Subject: RE: Planning Consultation on M/28/20/DOC

APPLICATION NO: M/28/20/DOC

Site Address: Poultry Farm 87 Yapton Road Middleton-On-Sea PO22 6DY

Description of Works: Approval of details reserved by condition imposed under ref M/45/16/PL relating to Condition Nos 10 - foul water drainage, 11 - surface water drainage, 13 - discharge of flows to watercourses and 14 - SuDs

Site: YAPTON POULTRY FARM
Project: MIDDLETON RESIDENTIAL
Date: 01/07/2020
Drawing: SITE VISIT DISCUSSION
APPENDIX 02

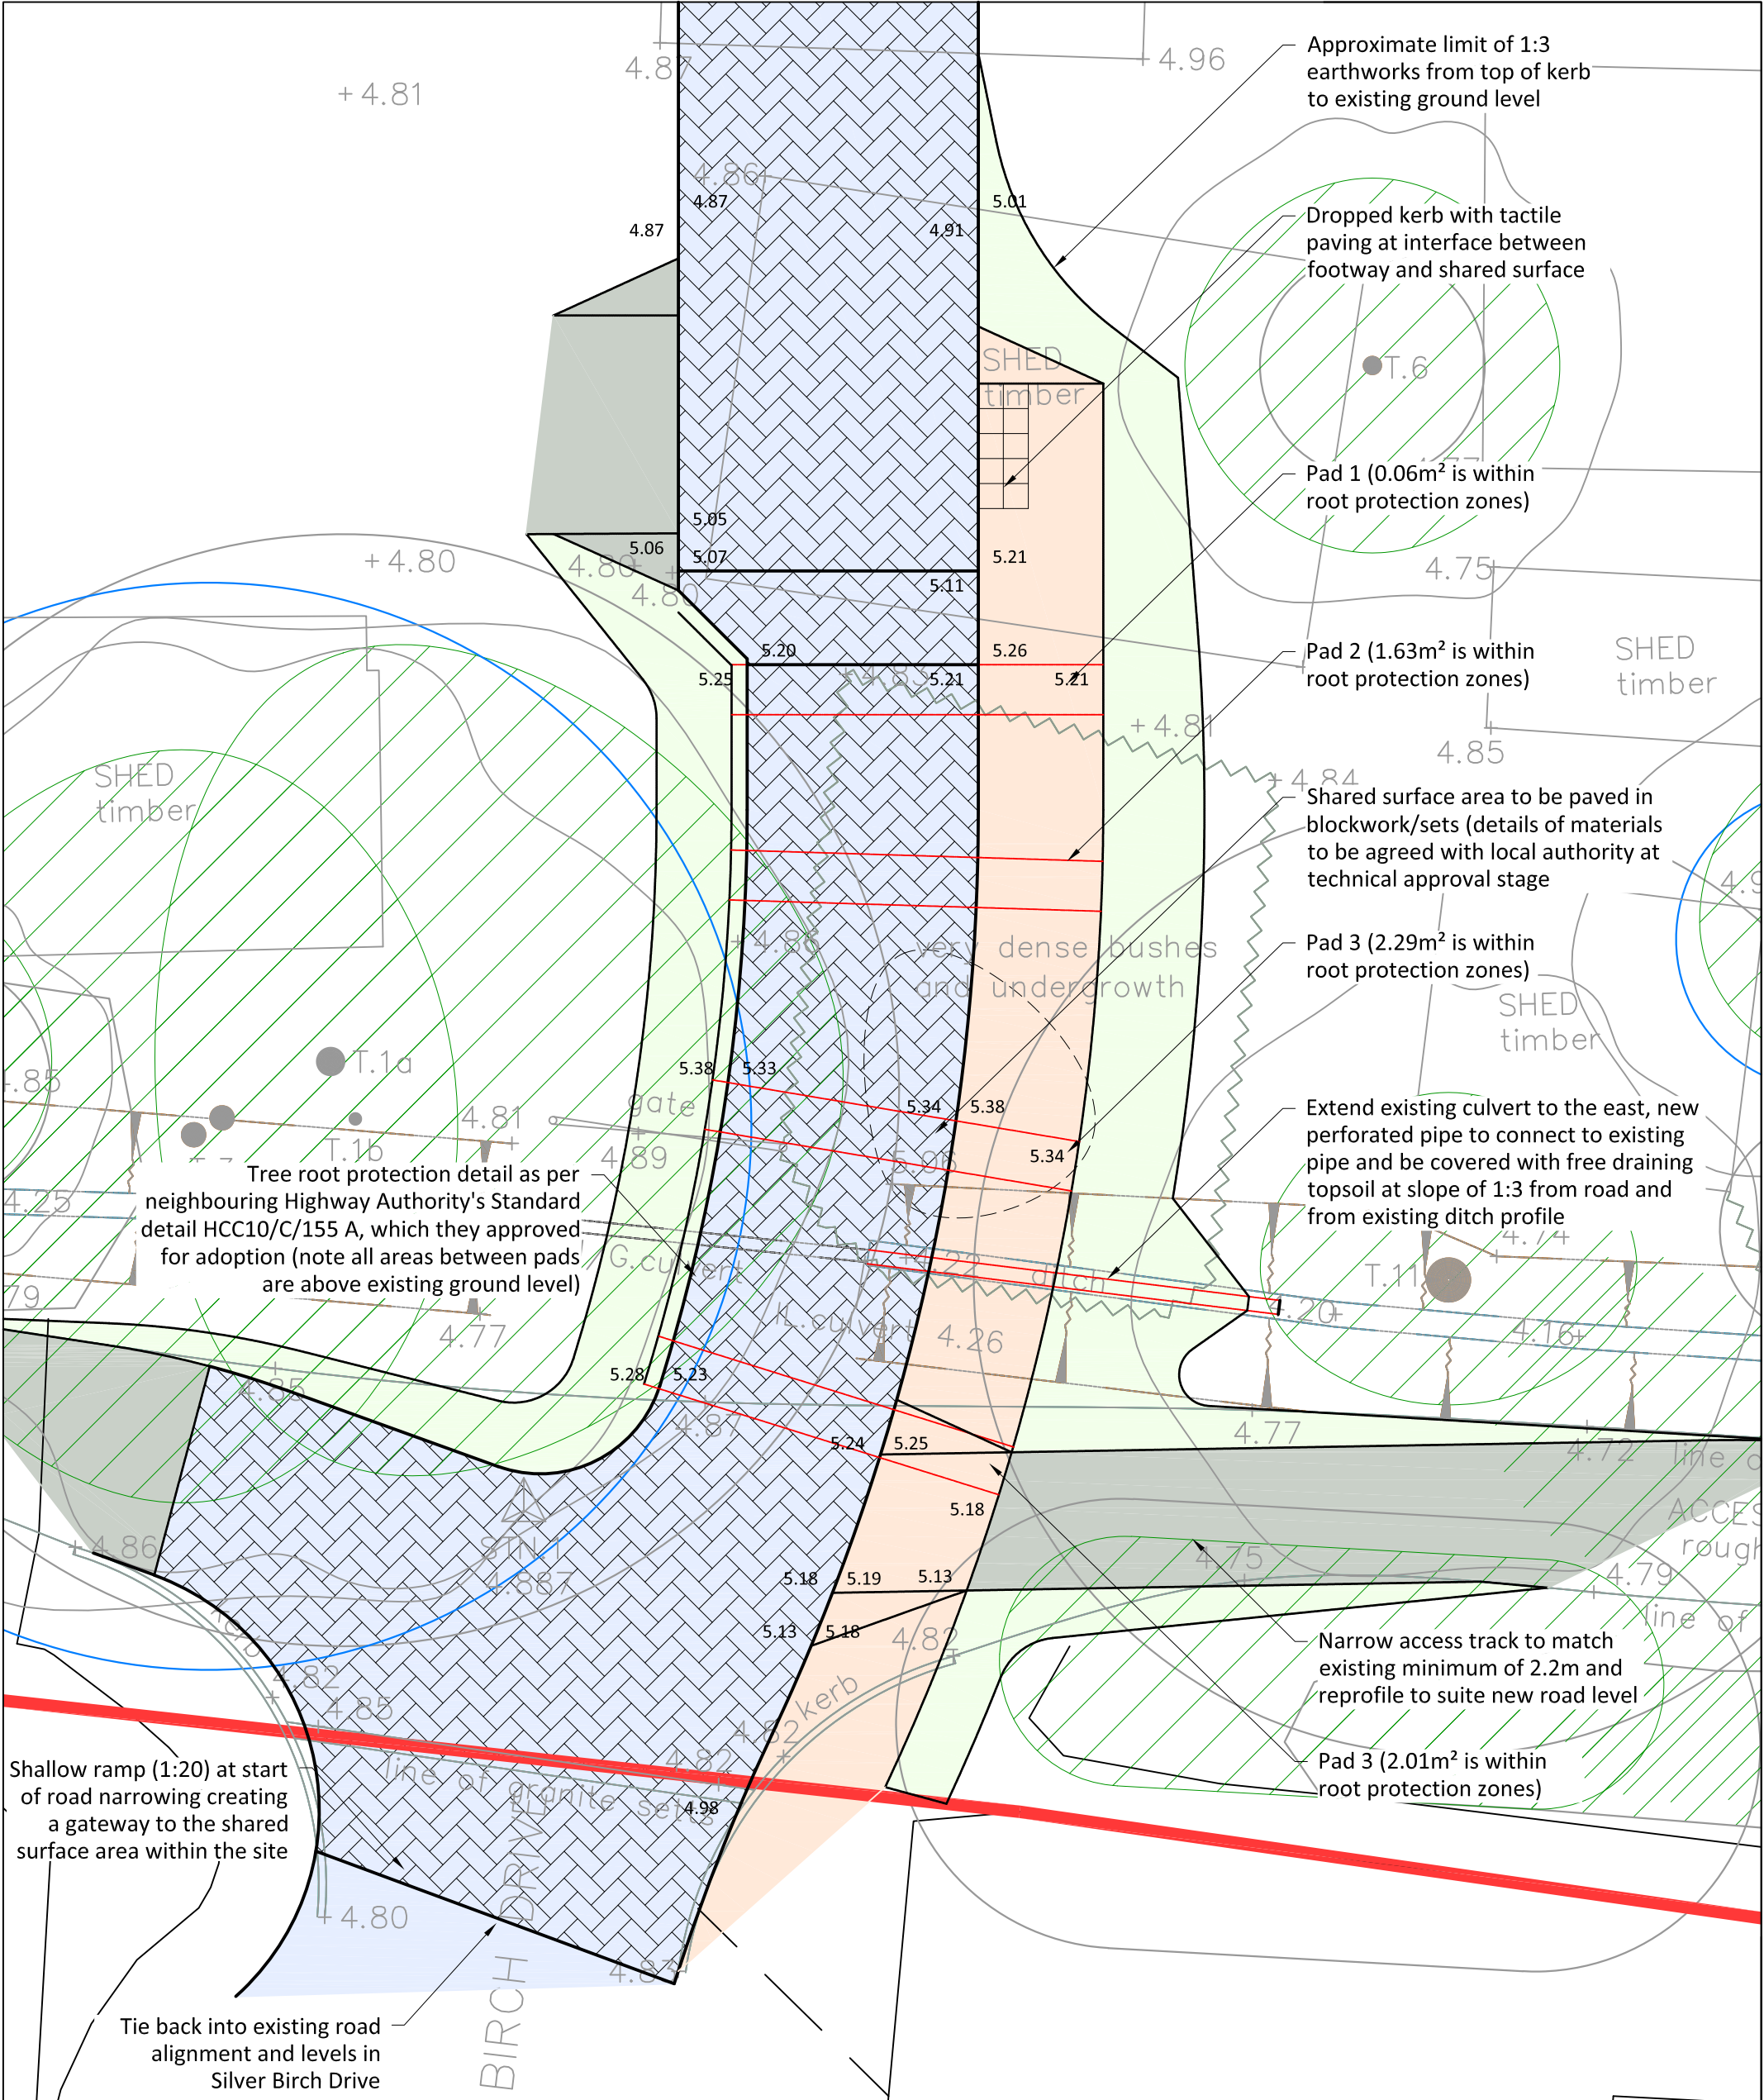
Regarding the ditches on the southern boundary, it is very likely that these will need improvements and I suggest a meeting takes place on site to look at these. Land Drainage Consent will be required for any alterations to them, including culverting and any discharge structures. This will all need to be fully detailed on the drawings.
